DOC20/935057

Senders ref: SSD 10382 (City of Sydney)

Subject: Notice of Exhibition – Student Accommodation, at 90-102 Regent Street, Redfern (SSD 10382)

APPENDIX H01

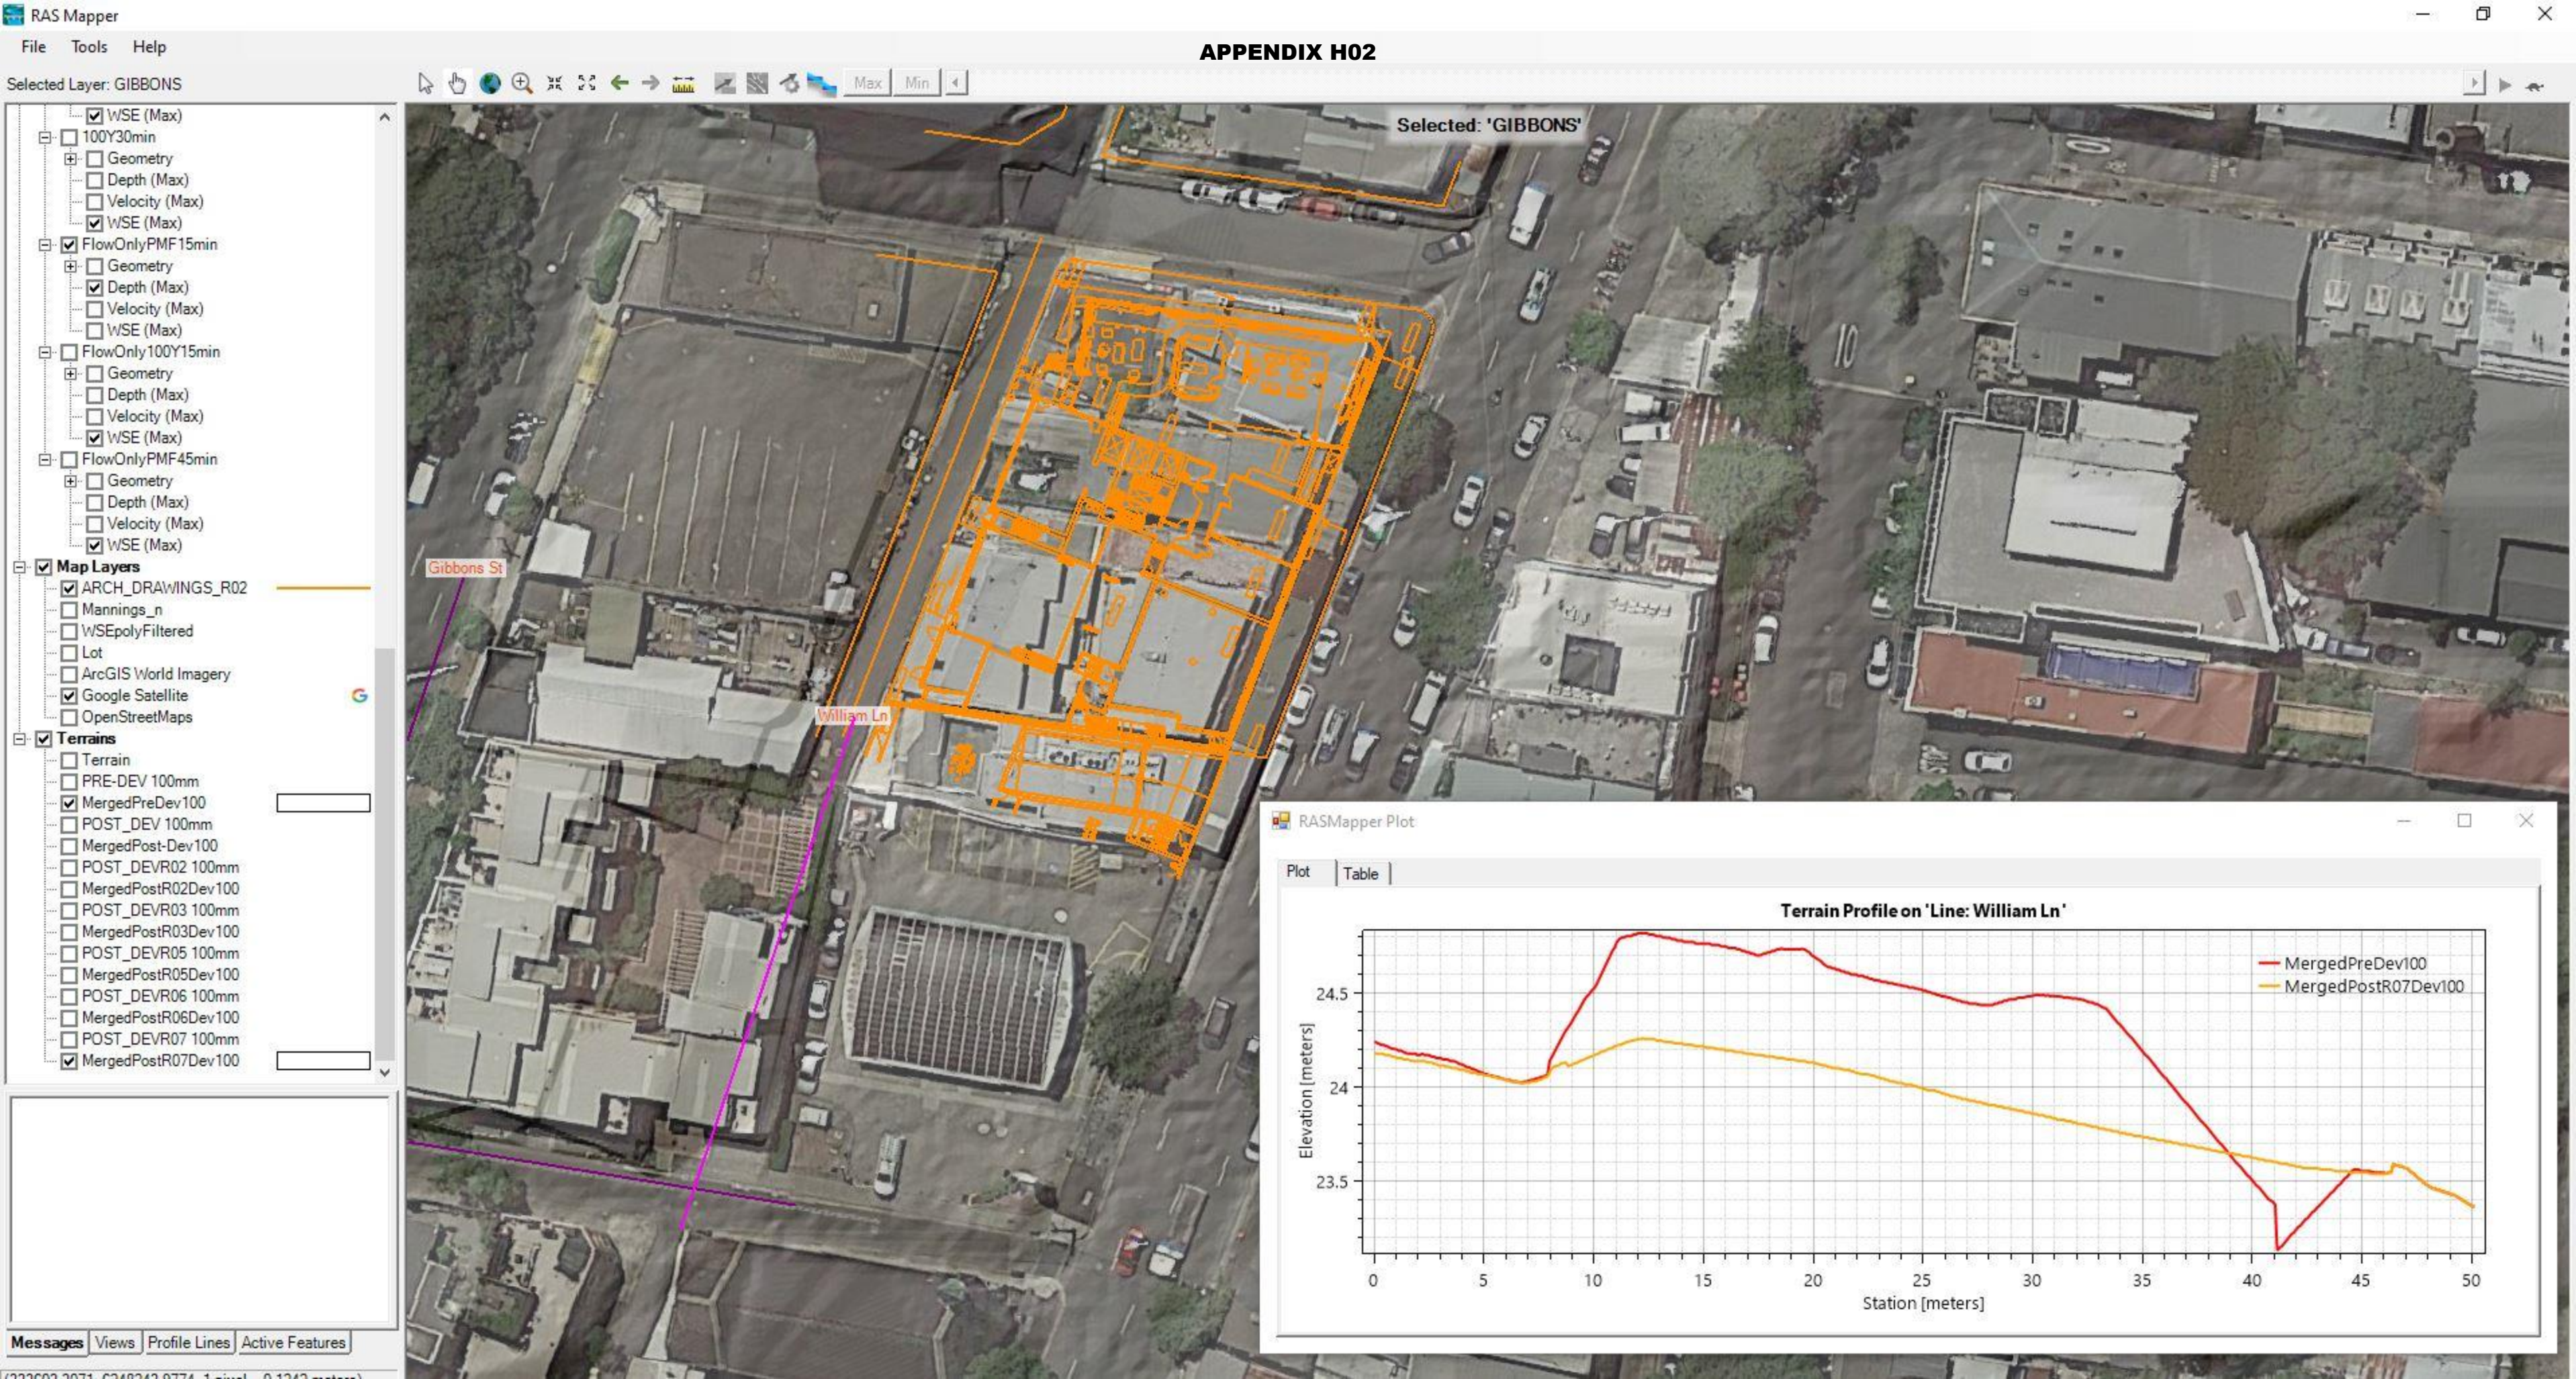
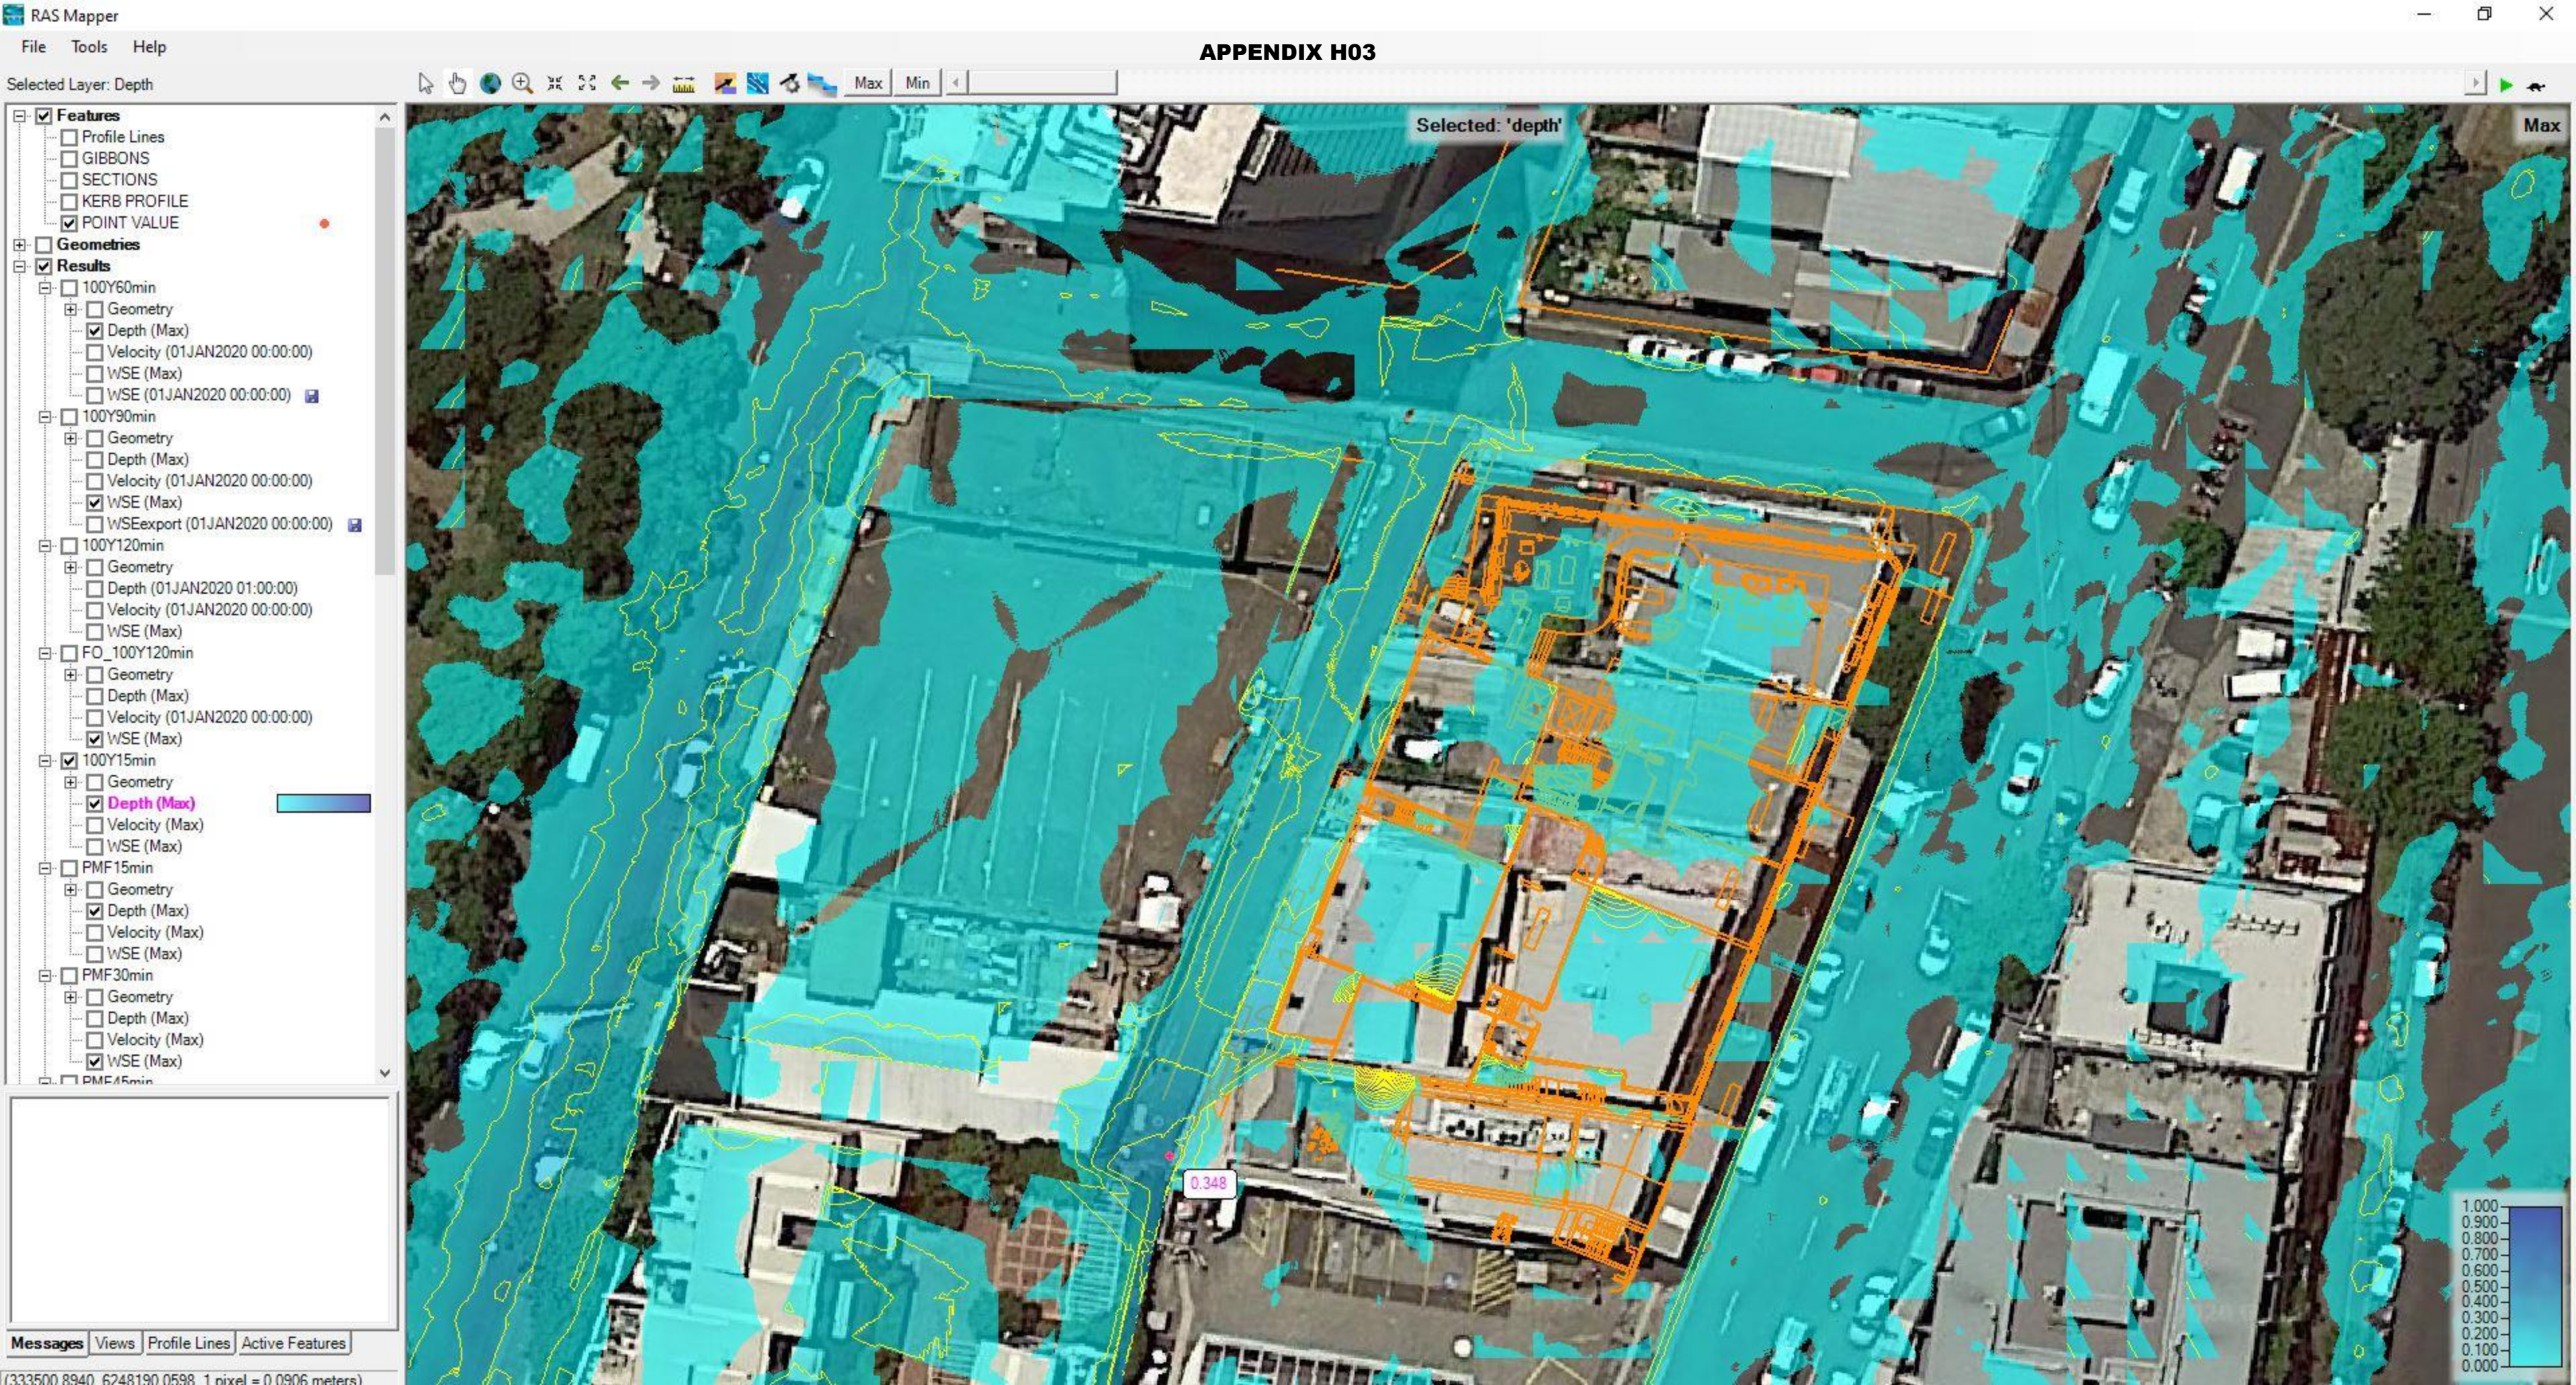
Flood planning levels have been provided, but it is unclear whether these are based on pre or post development modelling. Clarification is required. As stated above, the post development flood information cannot be used at this point. The proposed building includes a basement for bicycle storage, which requires all entry points to be above the 1% AEP flood level plus 500 mm freeboard and the PMF level. The PMF levels have not been calculated and are required for this assessment. EES notes that this requirement has not been met.
